**ANGEL PLACE
LEVEL 8, 123 PITT STREET
SYDNEY NSW 2000**

SSDA 8865 MOD 1- RESPONSE TO REQUEST FOR FURTHER INFORMATION

This letter has been prepared by Urbis Pty Ltd on behalf of Sydney Catholic Schools (SCS) in respect of the Section 4.55(2) application to modify the State Significant Development Application (SSD-8865) for concept approval and the staged construction of the St Anthony of Padua Catholic College at 125-165 Tenth Avenue and 140-170 Eleventh Avenue, Austral NSW 2179 (the project).

F

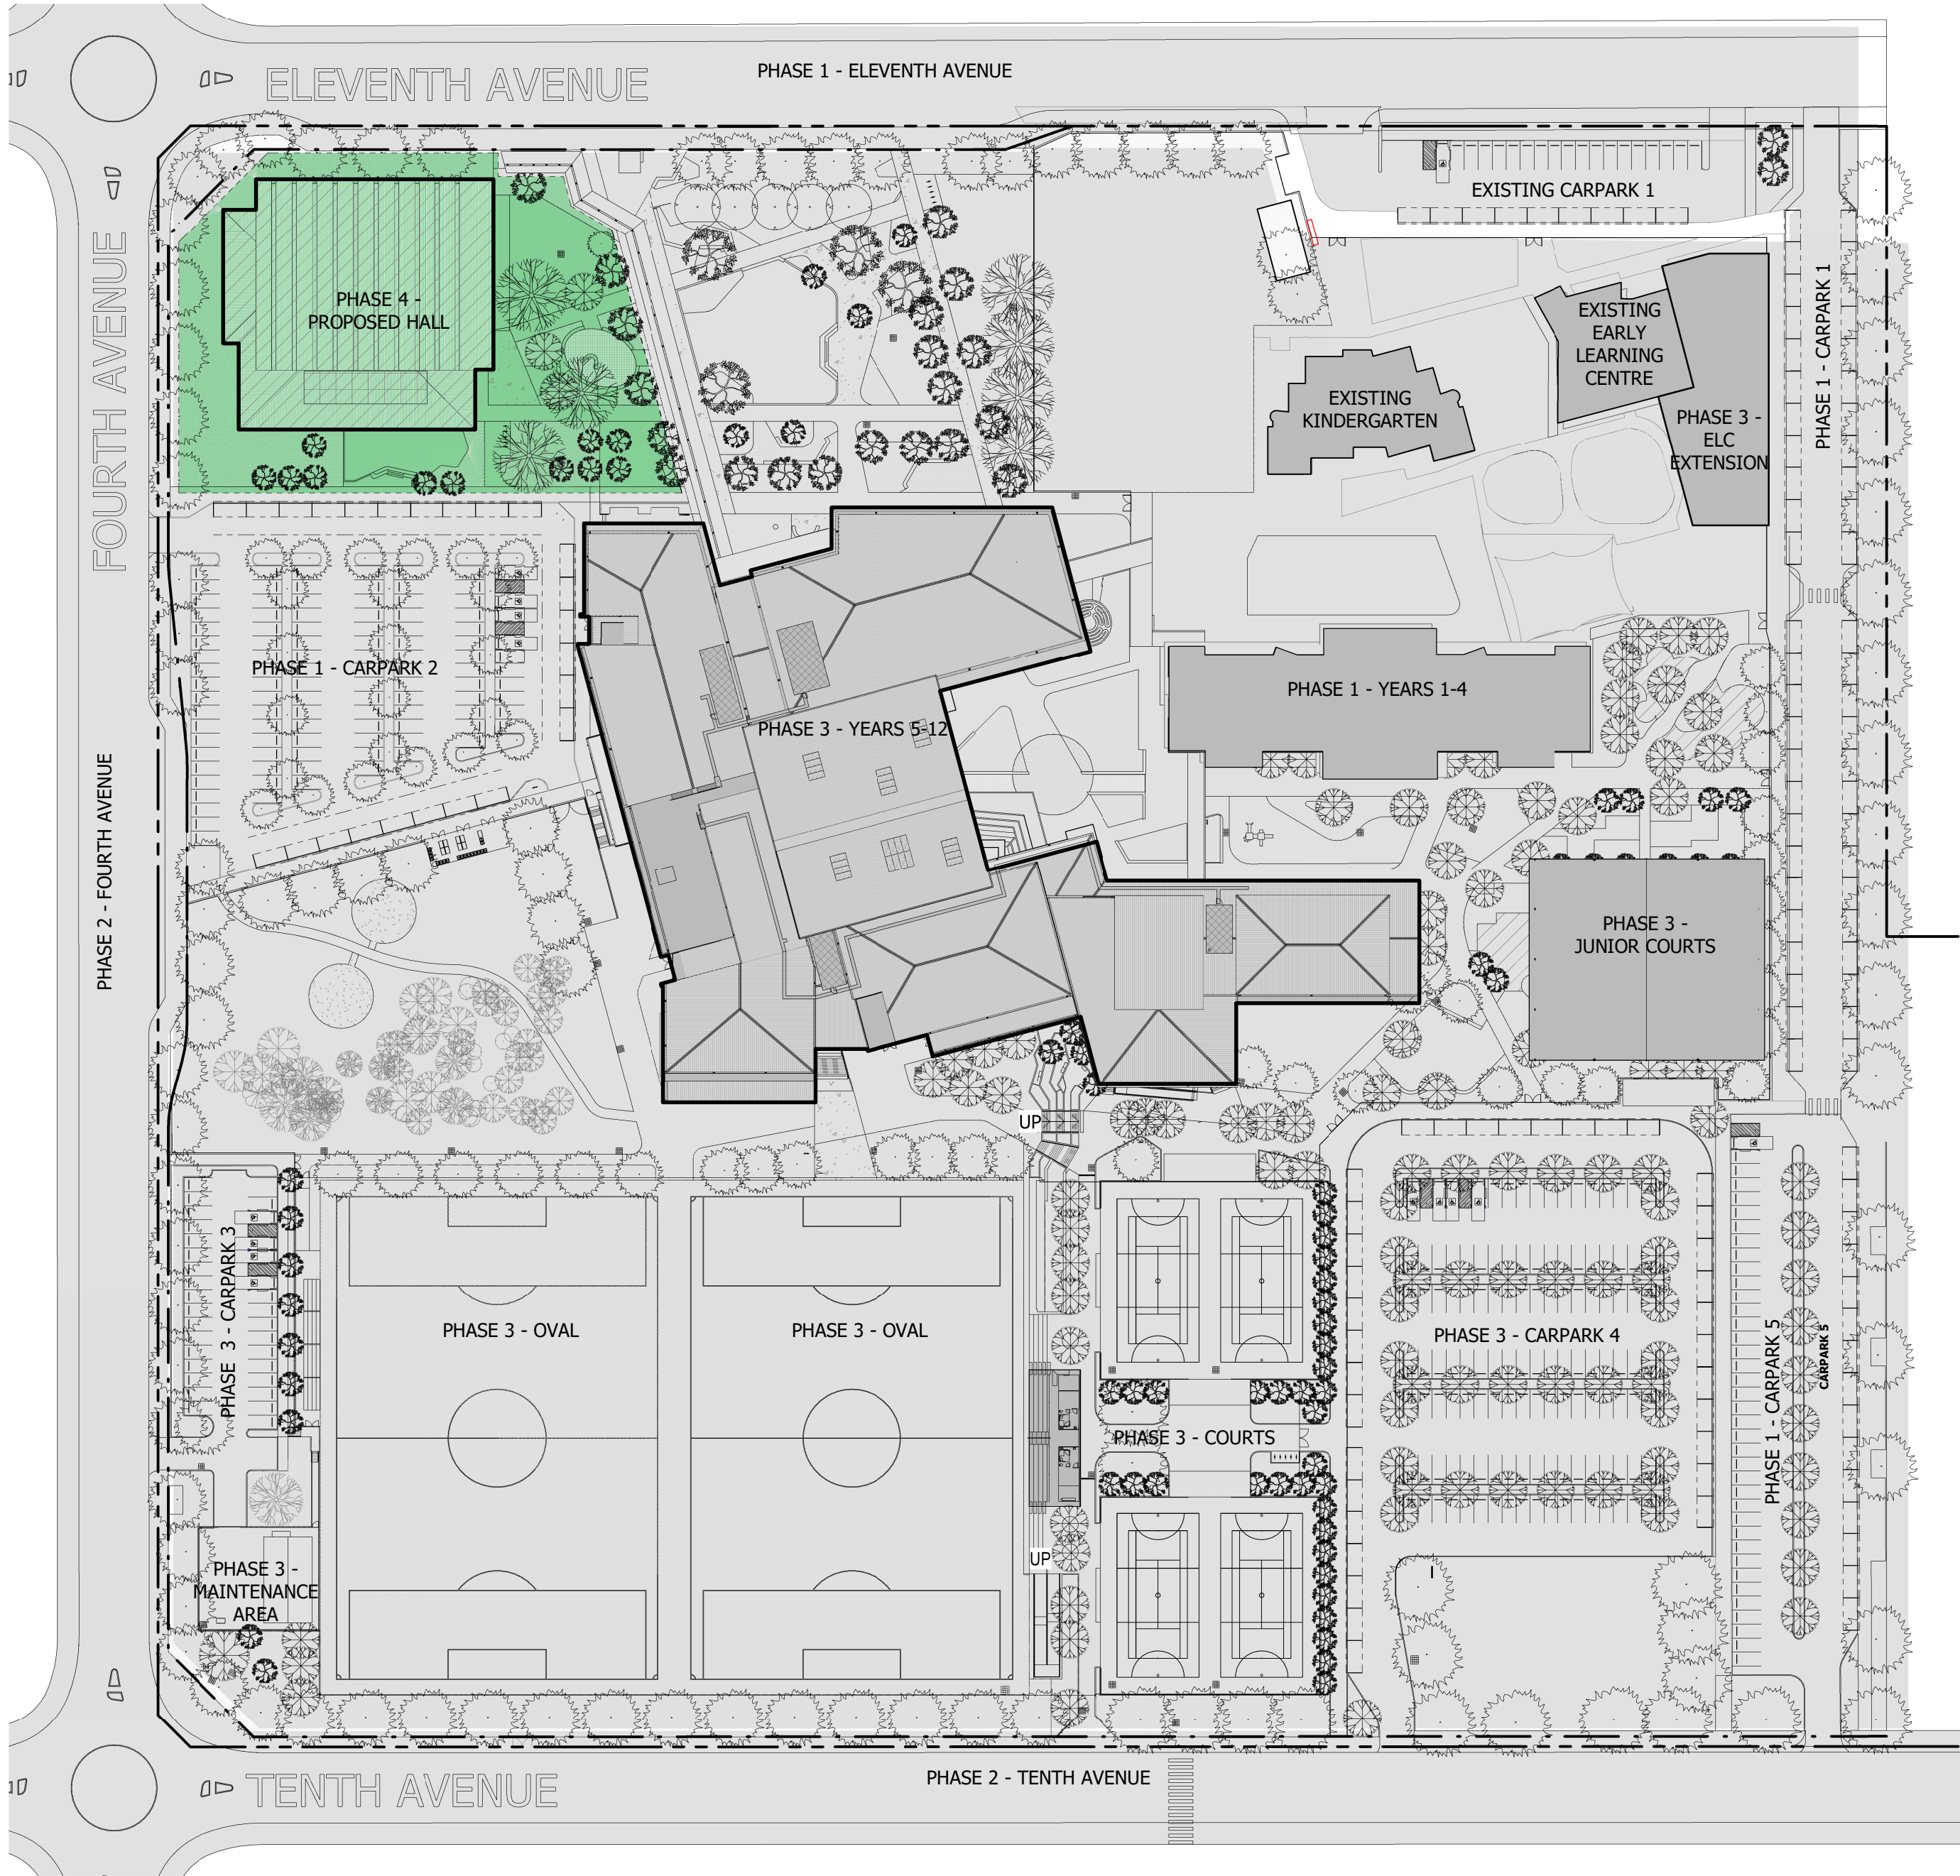
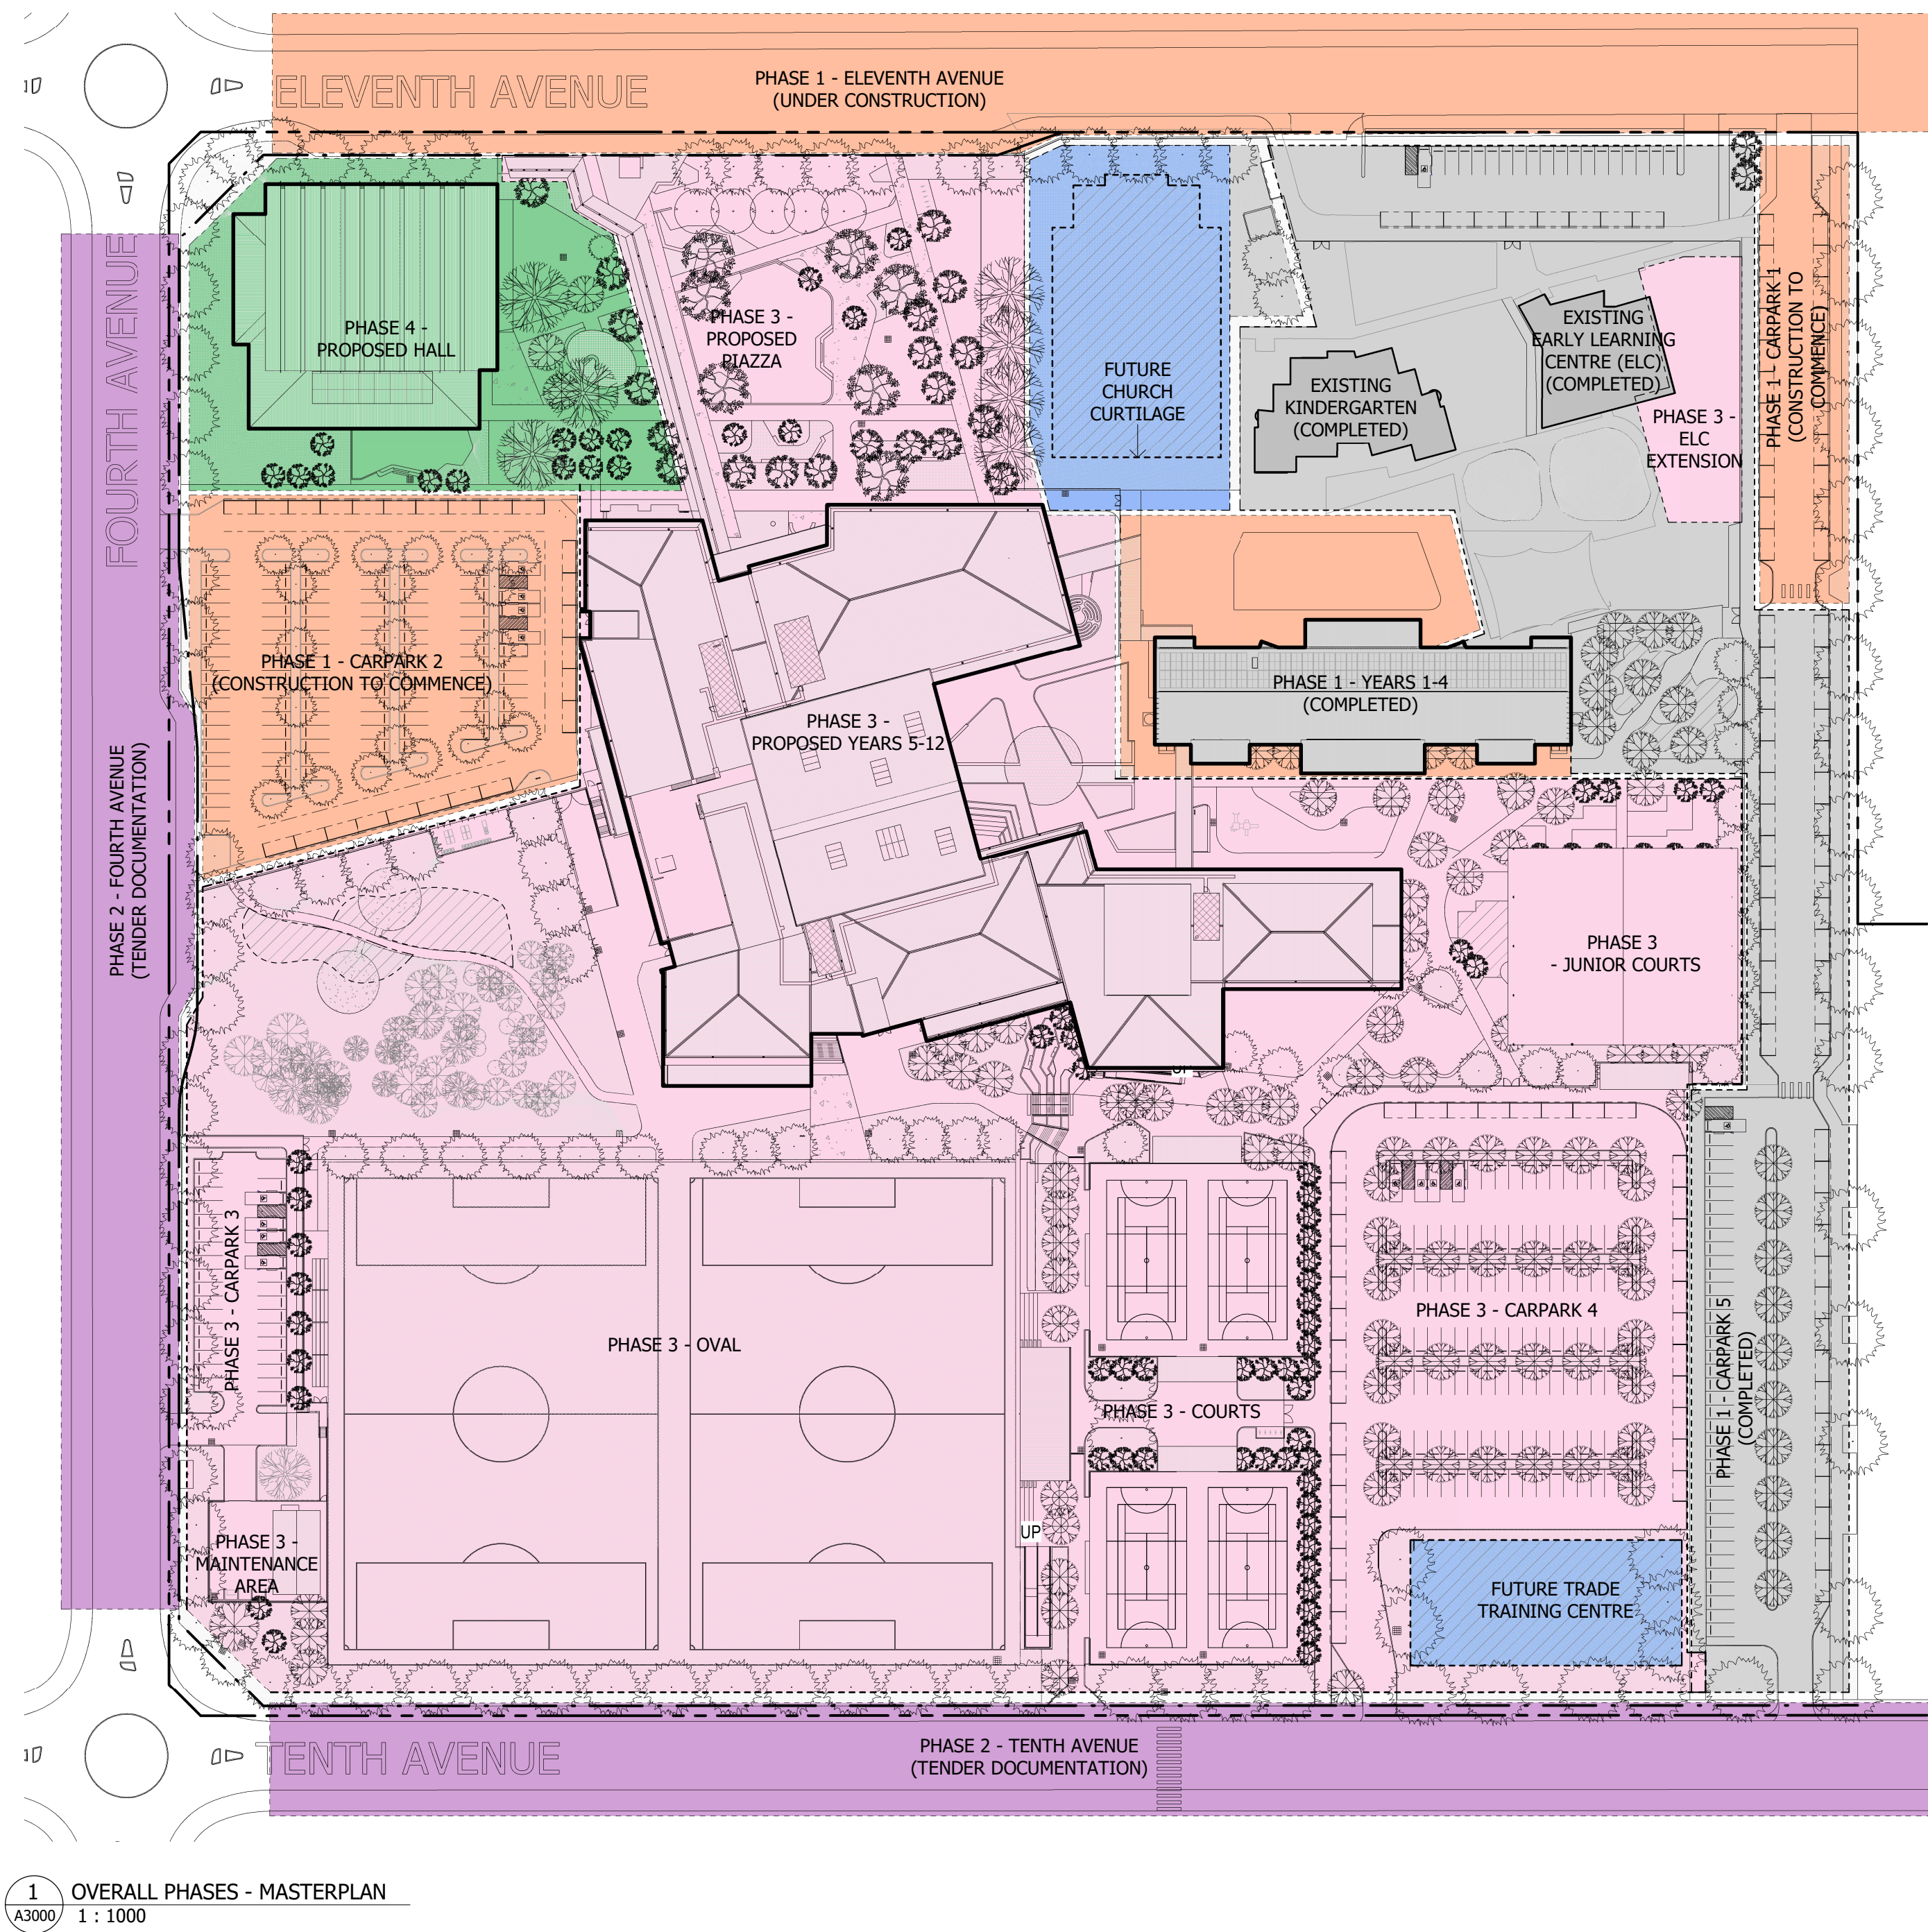
4. Provide amended architectural drawings to demonstrate the proposed bus shelter.	Updated Concept Approval site plans and construction phasing plans showing the location of the proposed bus shelter are included at Attachment A .

The proposed bus shelter is now shown on the Concept Approval site layout and is identified as part of Construction Phase 3.

1 ENVELOPE - NORTH ELEVATION
A11003 1 : 500

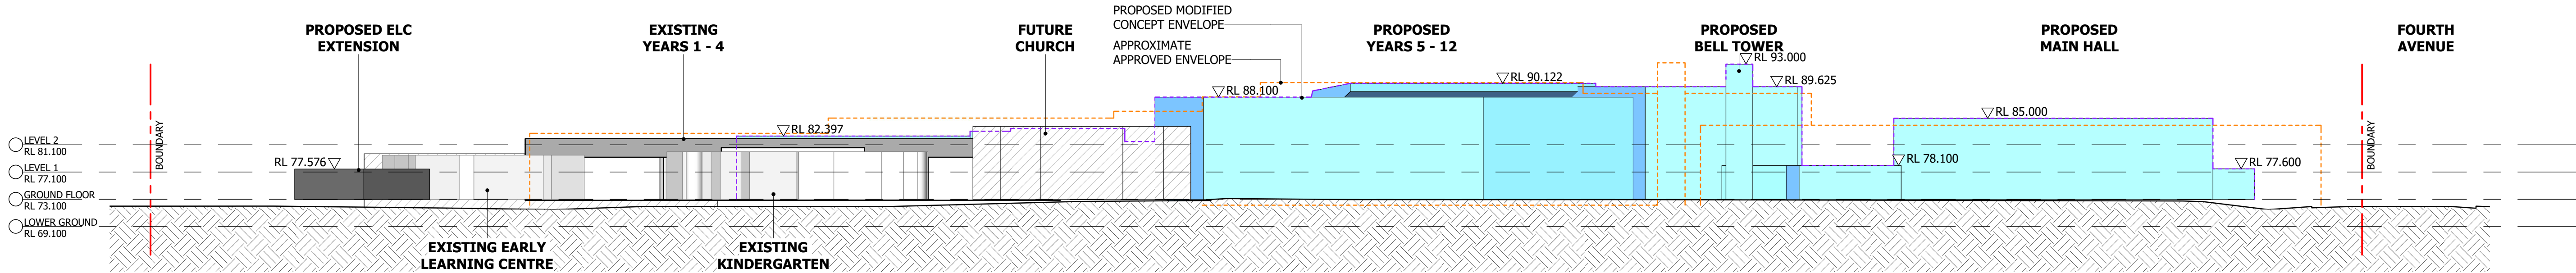
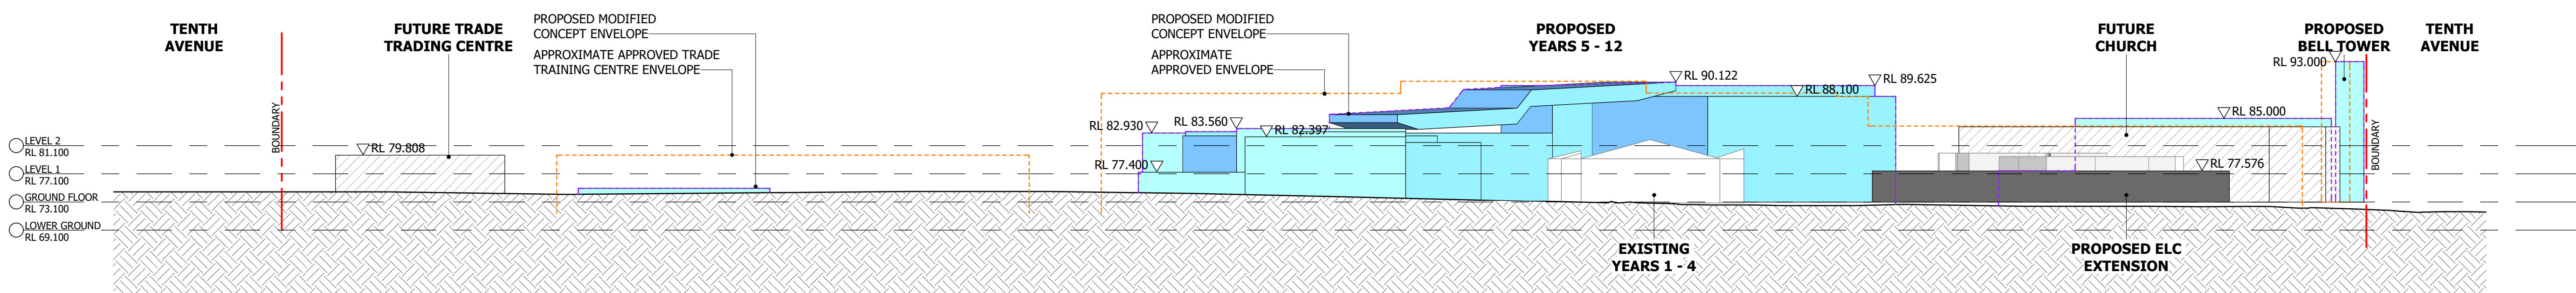
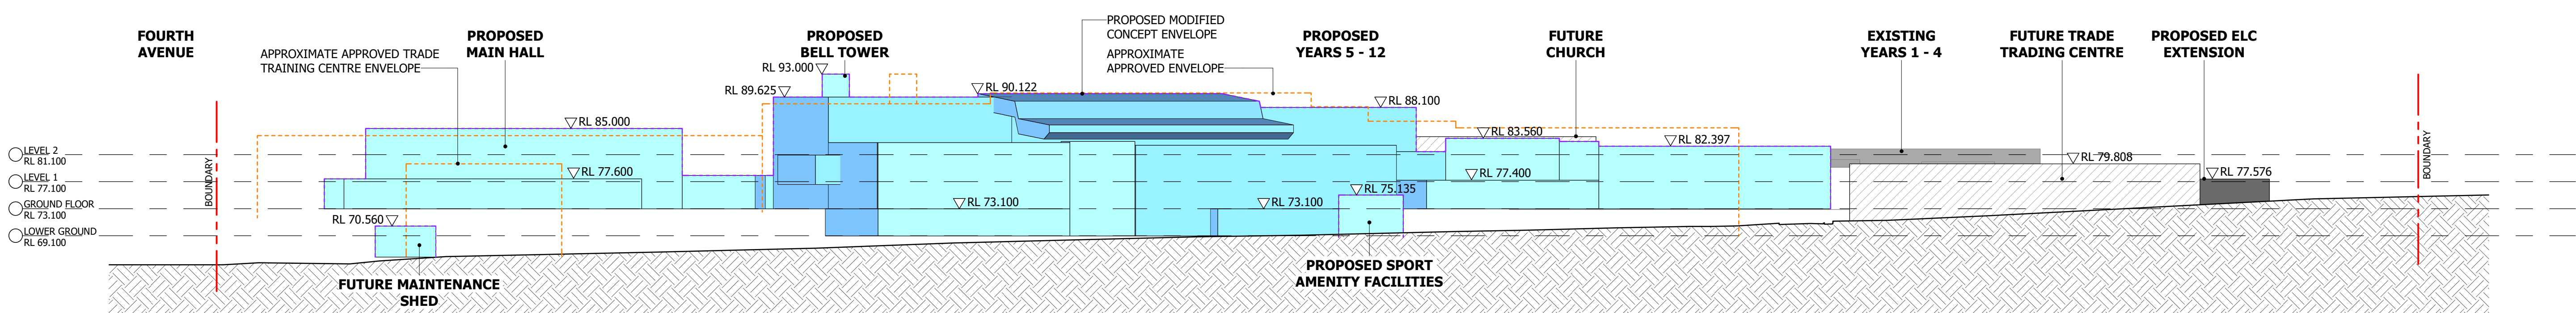
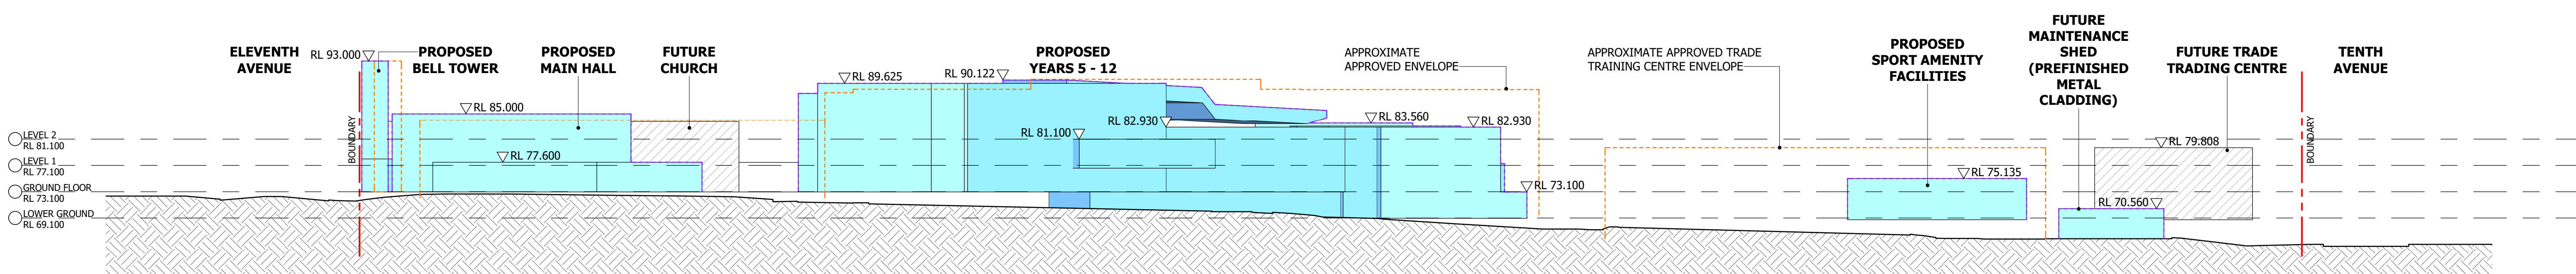
10. All architectural drawings must show RL level to top of roof and rooftop services, as consistent with the approved drawings. For example, the height of the roof of the main school building appears to extend beyond roof level RL shown on the plan.	The updated architectural plans identify the RL level to top of roof and rooftop services. Refer Attachment A.

DWP has reviewed the design refinements in relation to the Concept Approval site layout and elevational envelope. This has resulted in adjustments to the Concept Approval site layout and to the Concept Approval elevations. To illustrate this, additional plans have been included in the architectural set showing the difference between the approved site layout and elevations and the proposed modification (refer drawing AA0101 and AA0102).

The maximum RL of the main hall has also been adjusted from RL83.985M to RL 85M. These changes to the maximum approved heights have arisen as the original design as approved did not include allowances for adequate structural depth, future roof top plant or servicing requirements for the buildings.
